DRAINAGE AND TRANSPORTATION INFORMATION SHEET

PROJECT TITLE: NEW TRAINING/STORAGE FACILITY ZONE MAP/DRG. FILE # L-18-Z
DRB#: _____ EPC#: _____ WORK ORDER#: _____

**RE: New Training & Storage Facility
Engineers Stamp Date 06/12/15 (L18D074)**

This letter is in response to your comments by letter dated June 29, 2015. All of your comments have been addressed as follows:

A1 GRADING AND DRAINAGE PLAN  
SCALE: 1"=10'

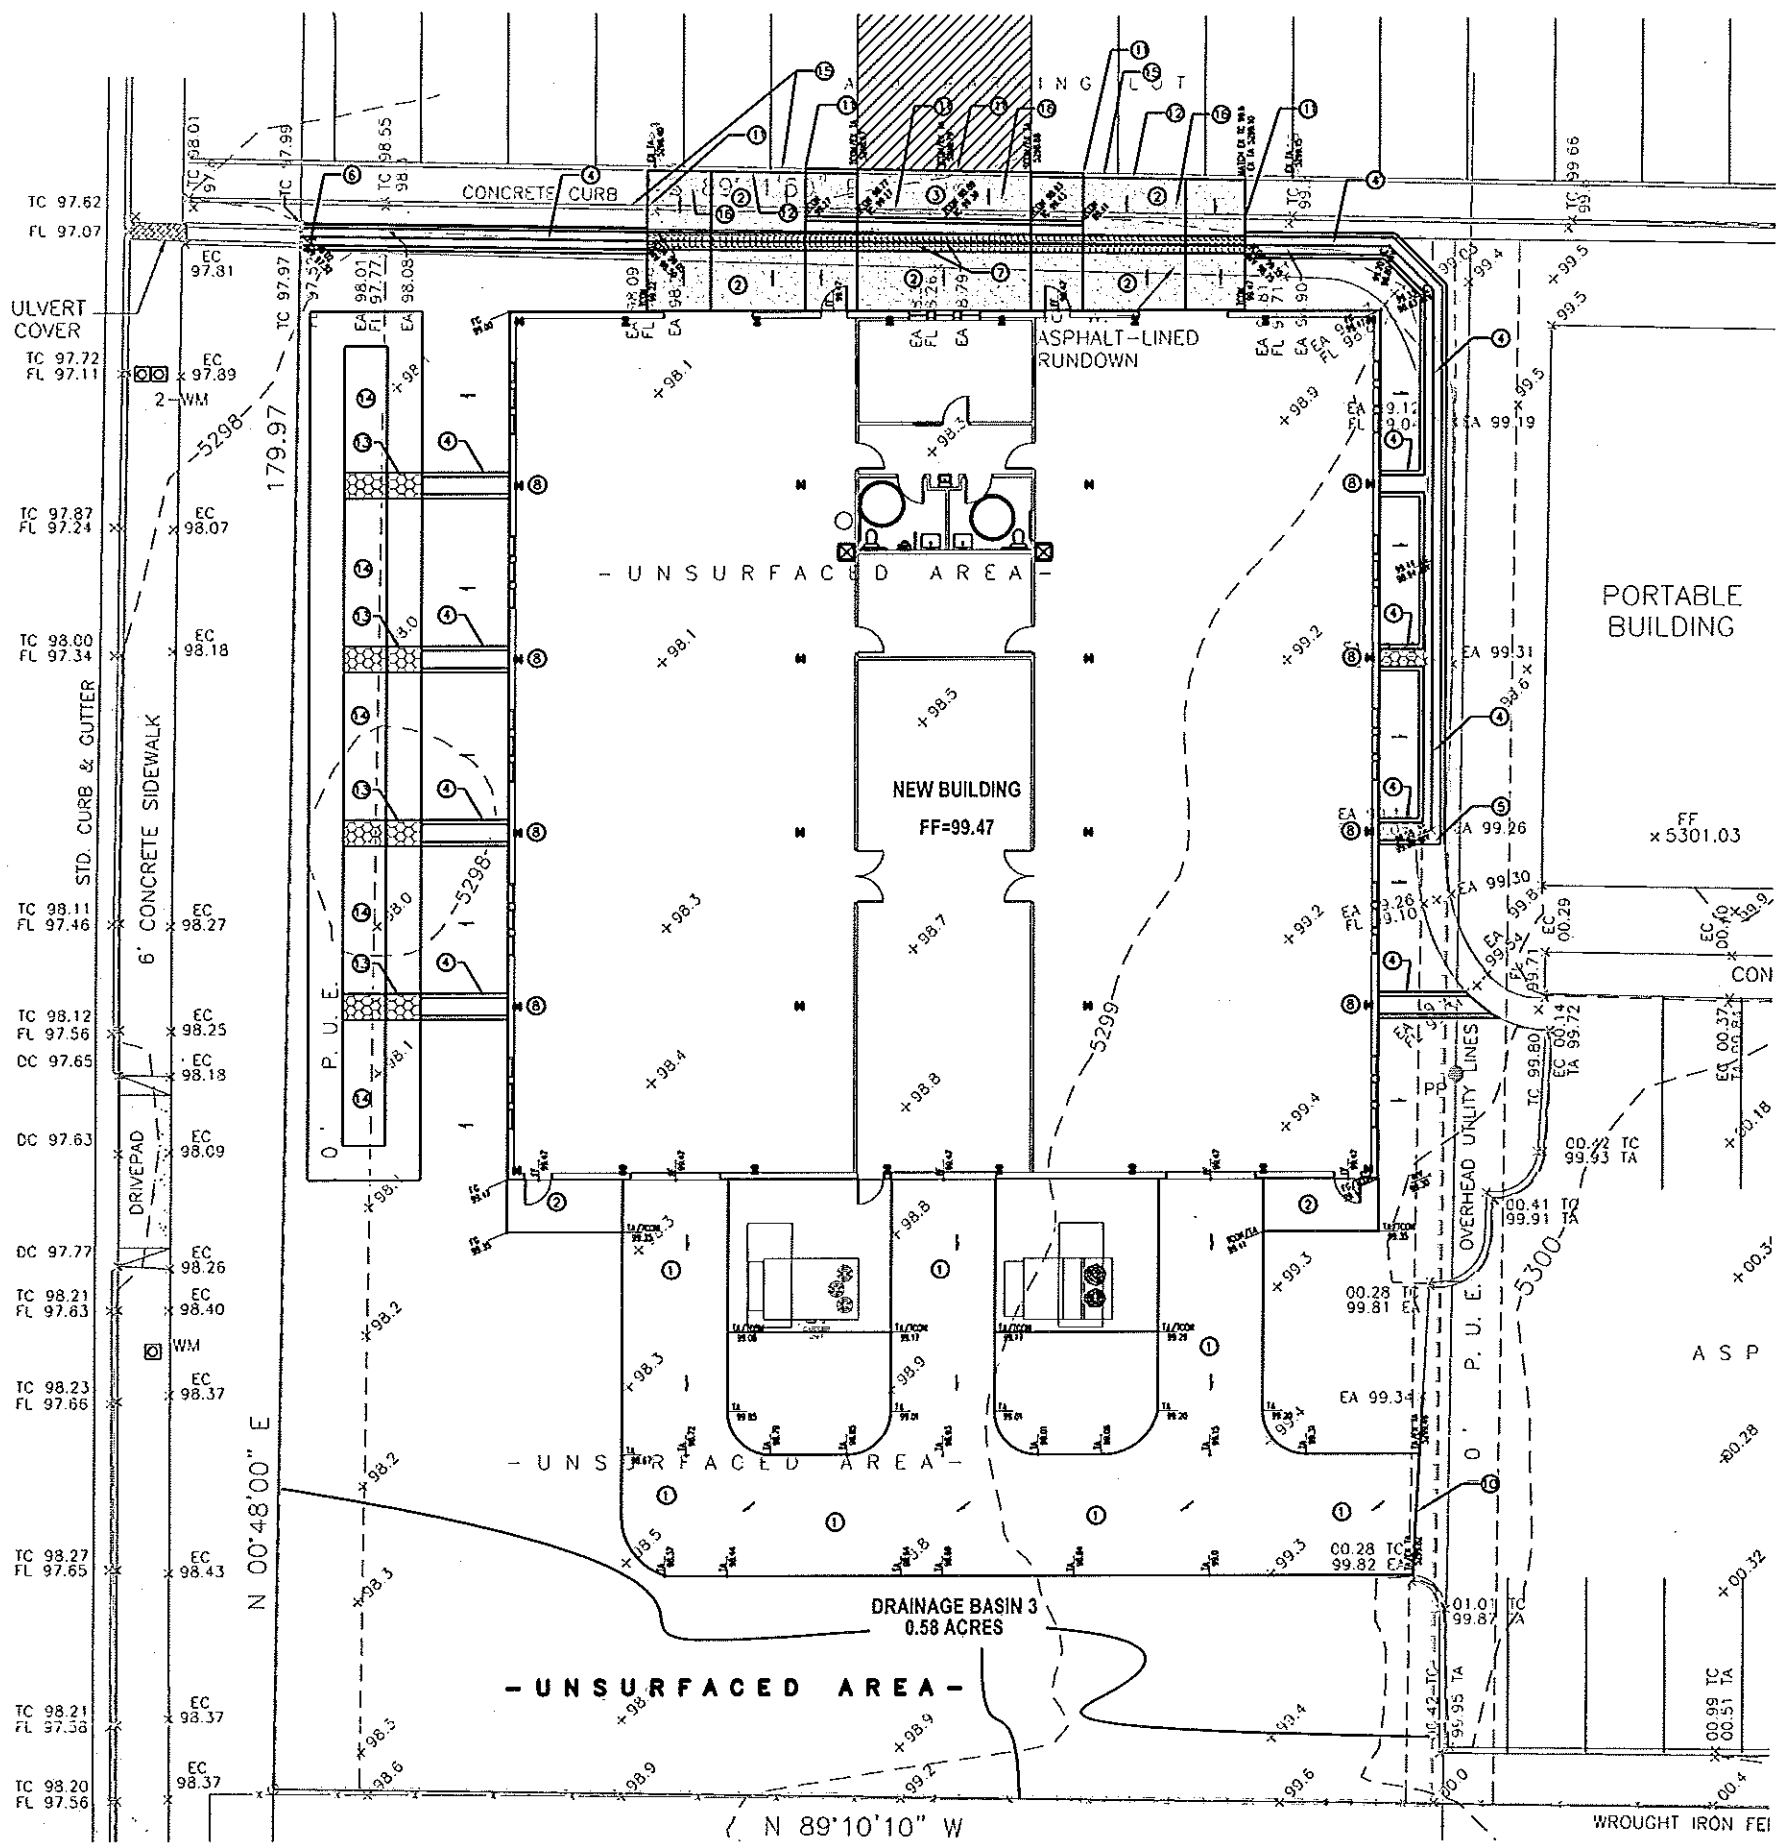
2. Provide the type of surface in the south area. A look at the aerial map shows pavement. How will the flows exit this area?
The area in question is actually dirt/base course as it stands today. The flows will exist through a swale which we have added on sheet C-102. The new swale will begin near the east edge to the south of the property and run west then head northeast around the paved drive area and northwest to the first flush pond on the west side.

**D5** TYPICAL POND SECTION DETAIL  
SCALE: NOT TO SCALE

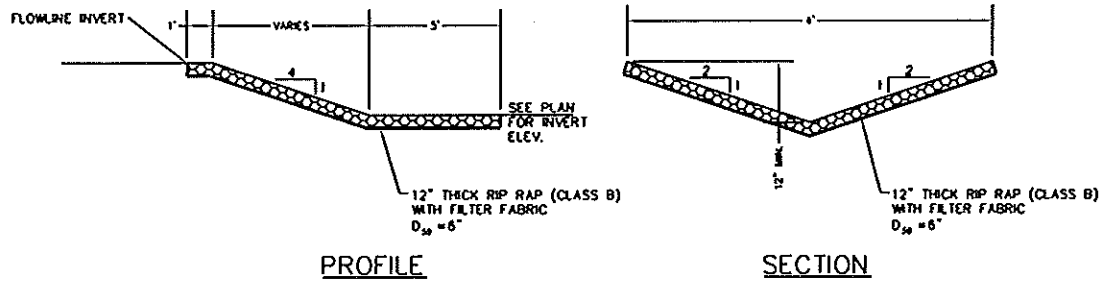
5. Sheet C-501 shows a typical pond section with a berm. Where is this berm located? If on the east side of the pond, how will the concrete channels enter the pond?

The berm has been removed from the detail on sheet C-501. The flows will be able to enter the pond through the concrete channels.
